21 January 2011

Mr Howard Reed
Manager Mining and Extractive Industries
Department of Planning
23-33 Bridge Street
SYDNEY, NSW 2000

Re: Carrington West Wing Modification (DA 450-10-2003 MOD 3) – Response to Independent Groundwater Review

APPENDIX 4  
CONCEPTUAL GROUNDWATER BARRIER WALL

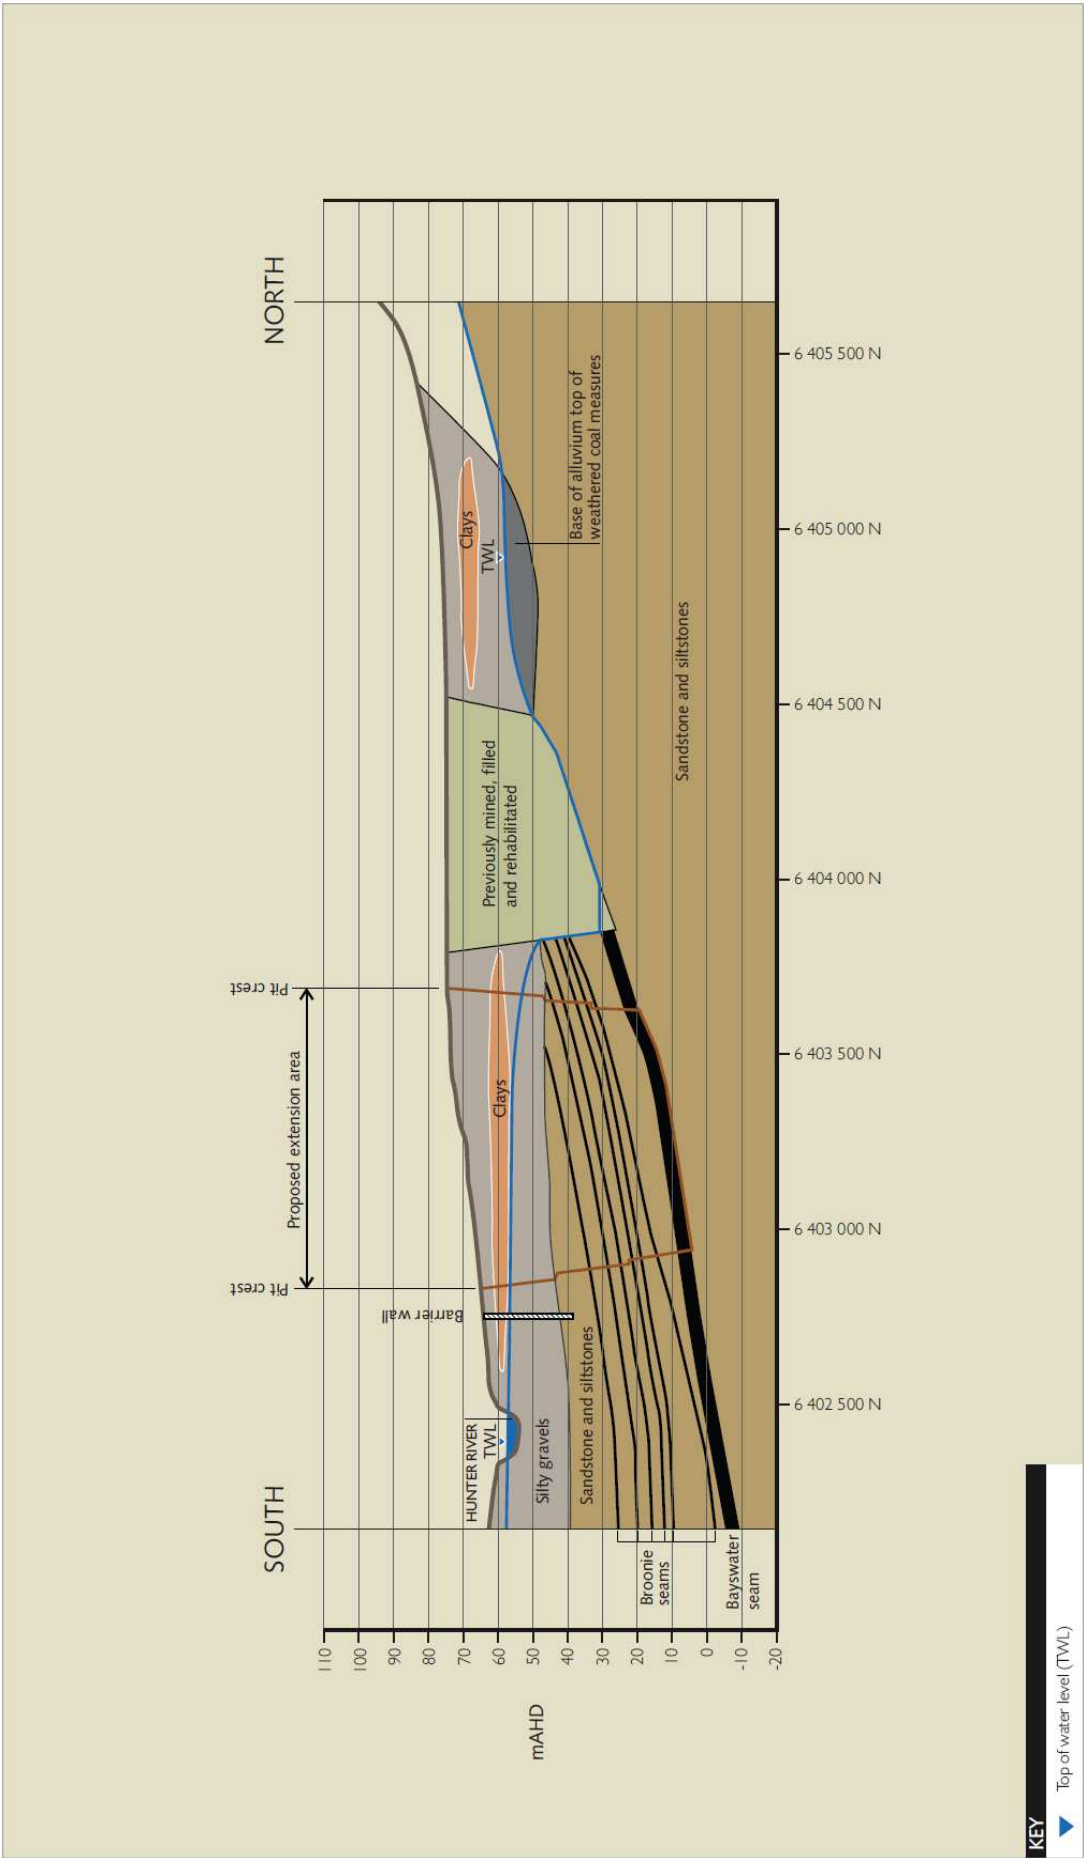
1. Updated groundwater modelling assessment:
 - a. Using Dr Kalf's recommended permeabilities for the groundwater barrier (or further evidence to demonstrate a permeability of 10^{-6} m/day could be achieved);
 - b. Consideration of secondary (fractured) permeability within interburden materials; and
2. A copy of the groundwater barrier design report for the constructed eastern paleo-channel barrier wall.

The Carrington West Wing Environmental Assessment was based on specifying a barrier wall permeability of 1×10^{-6} m/day for the western channel in the form of a slurry curtain bedded into the hard rock. The MER letter report assesses a scenario for a barrier wall permeability equivalent to the recently constructed eastern channel barrier wall of 5.8×10^{-6} m/day. For this scenario, the results indicate that river losses in the Carrington West Wing Extension of 0.14 ML/day compared to 0.05 ML/day for the permeability assessed in the Environmental Assessment. The permeability of the eastern channel based on the as-constructed permeability is predicted to result in a loss of 0.1 ML/day.

If the western barrier wall was constructed to the same permeability as the eastern barrier wall, an increase in losses of 0.04 ML/day in the western channel compared to the eastern channel (i.e. 0.14 ML/day – 0.1 ML/day) could occur. However, if the constructed permeability of the western channel is specified and constructed to achieve the permeability of 1×10^{-6} m/day as outlined in the Environmental Assessment, there would be a net reduction in the losses compared to the eastern channel with the as-constructed barrier wall permeability, by 0.05 ML/day (i.e. 0.05 ML/day – 0.1 ML/day).

Notwithstanding the above, Coal & Allied is committed to additional secondary permeability field-testing of interburden strata at three bores to the south of the barrier wall, as recommended. A revised Statement of Commitments including this commitment is enclosed.
